# Rezoning Transportation Analysis

Petition Number: #2022-123

**From:** Jake Carpenter, PE

Date	Description
12-28-22	First Review (TM)

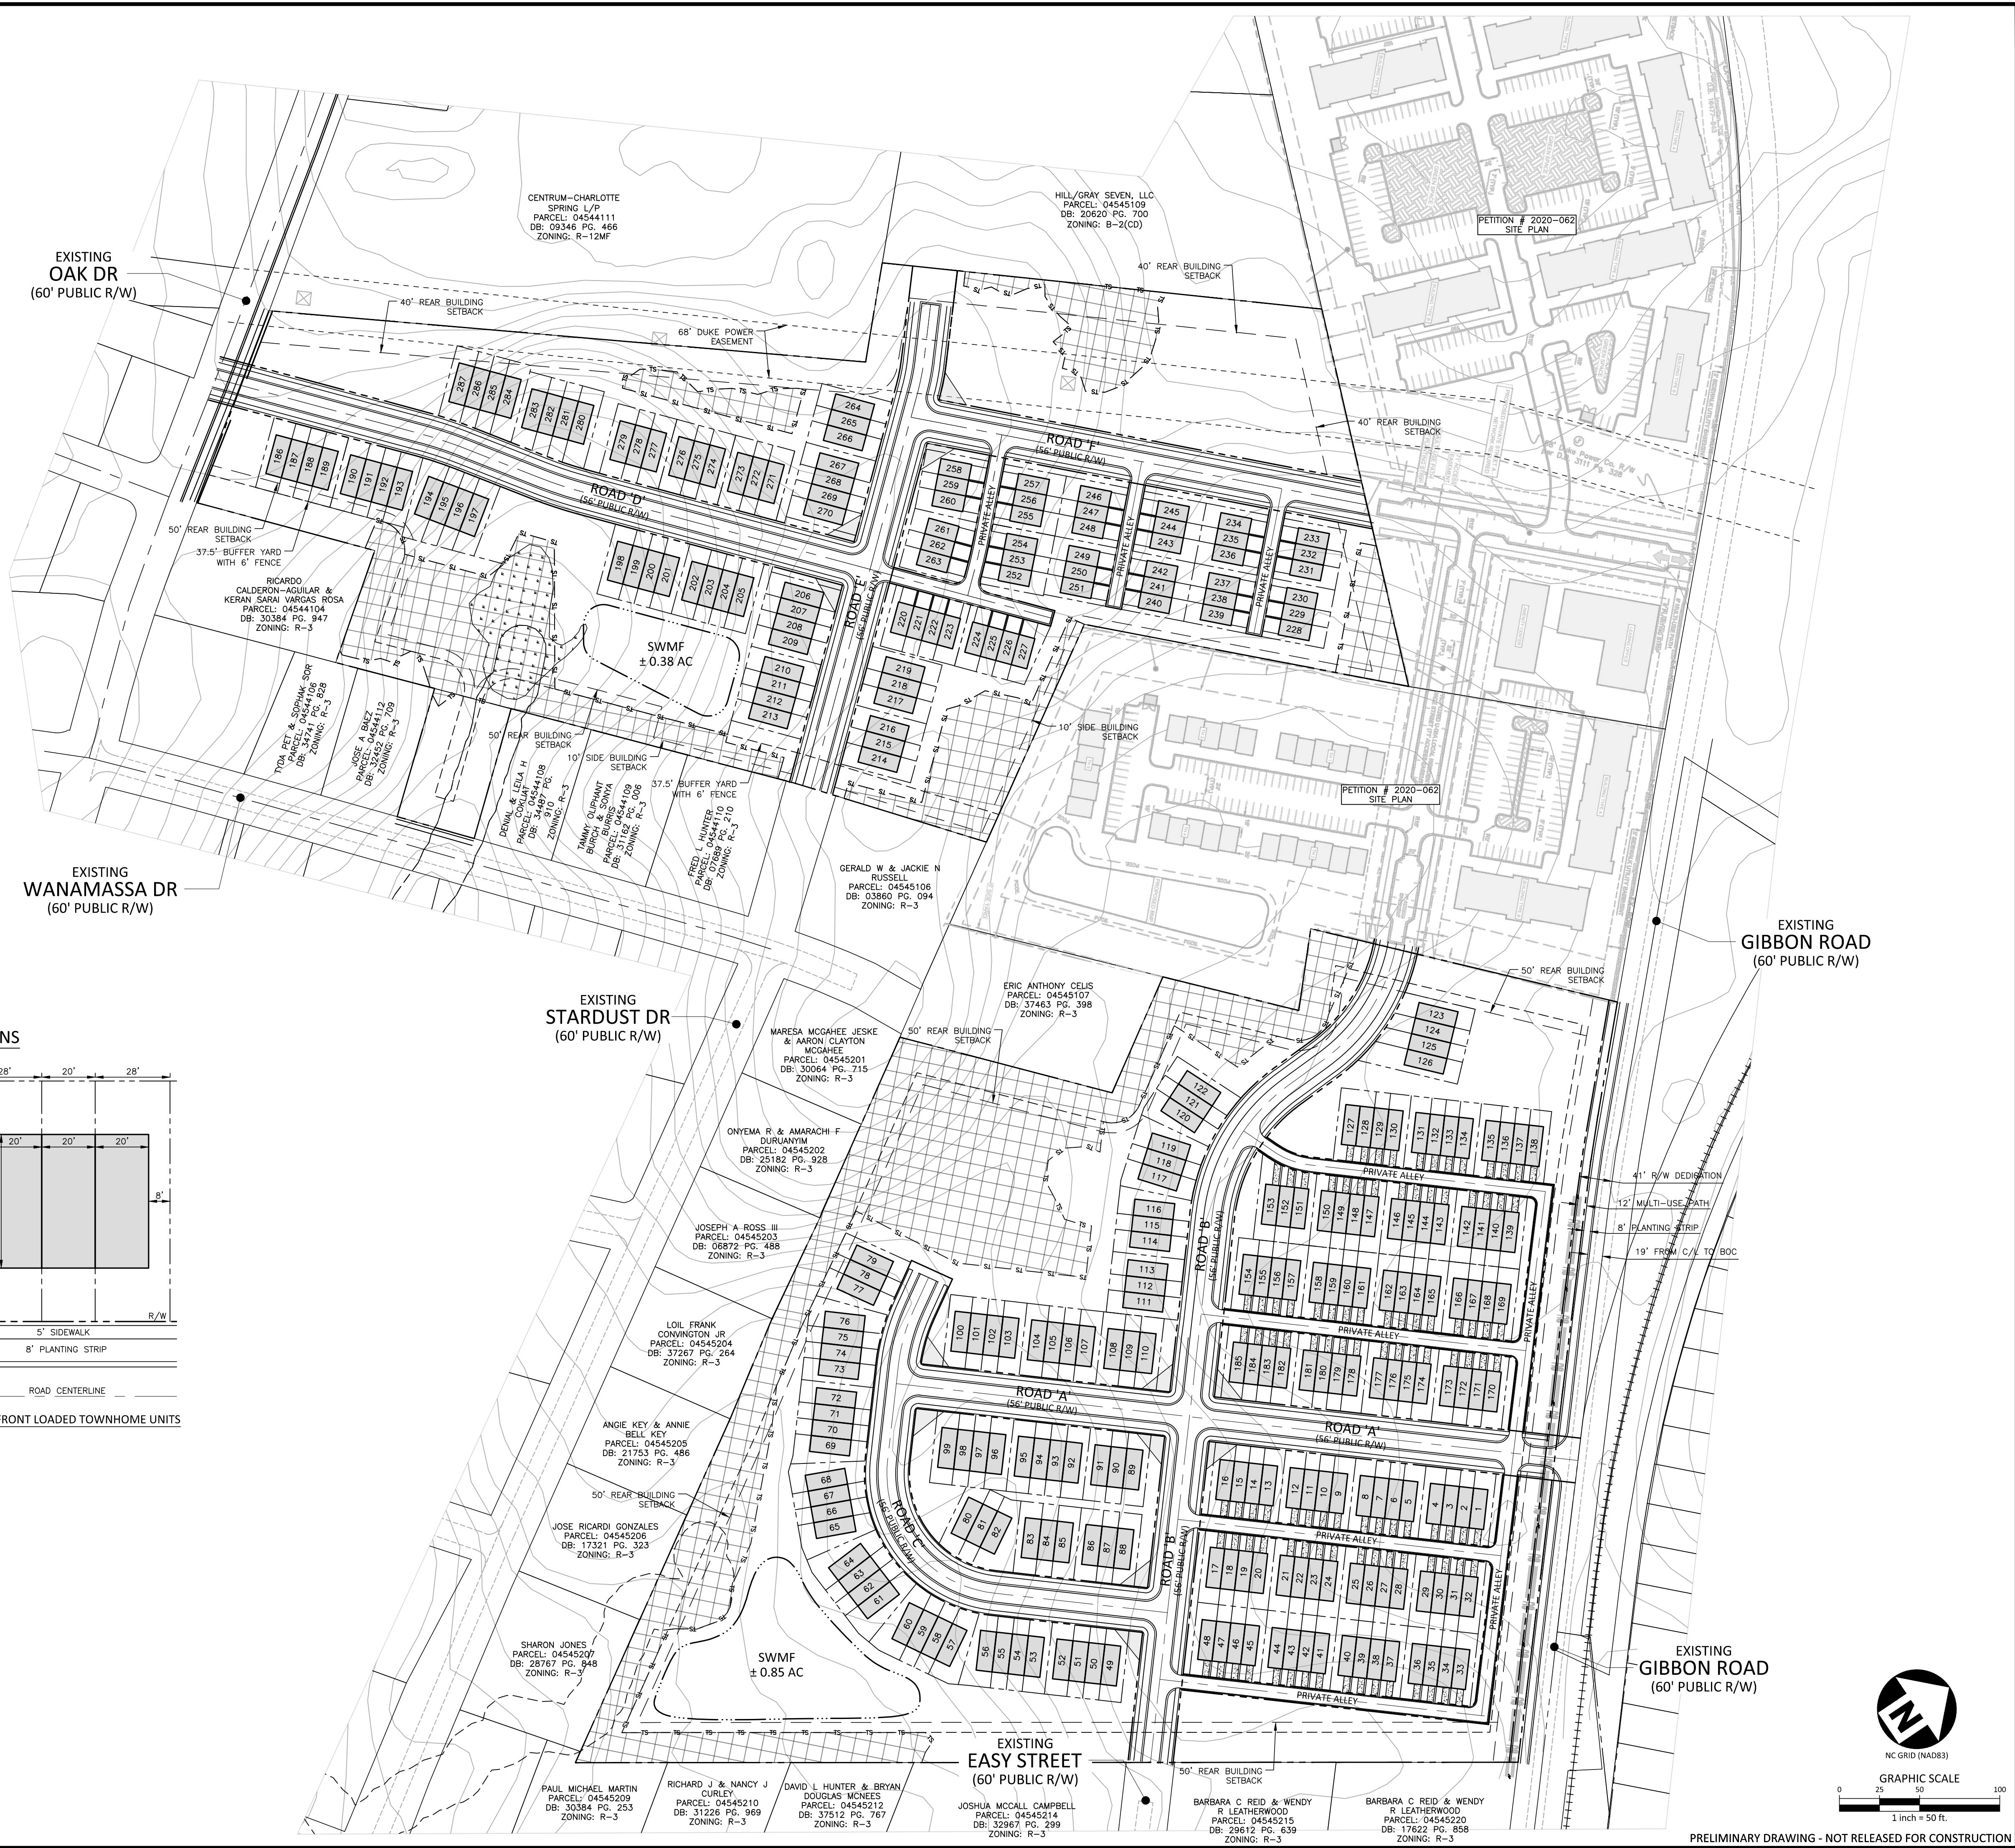
- a. **Gibbon Road:** Location of curb and gutter to be moved to 19 feet from roadway centerline to accommodate the Charlotte Streets Map with a roadway typical section of CLDSM 11.09 Minor Thoroughfare.

Label and dimension the curb and gutter from the centerline for each road on the site plan.

3. Revise site plan and conditional note(s) to commit to construct an 8-foot planting strip, and 6-foot sidewalk on all internal Public Roadways per Chapter 19. The site plan shall label and dimension both items from the back of curb and gutter or edge of pavement.

5. CDOT Requests site plan and conditional note(s) revision to commit to upgrading existing Easy Street to meet the CLDSM standard U-02.
6. Revise site plan and conditional note(s) to label each public roadway per CLDSM U-02 roadway typical section standards.

7. Revise site plan and conditional note(s) to commit to providing a turn around on public roadway C meeting CLDSM standards.

8. Revise site plan to provide a minimum internal stem length of 50' between radius returns along Road 'A', between Gibbon Road and the proposed internal alley.
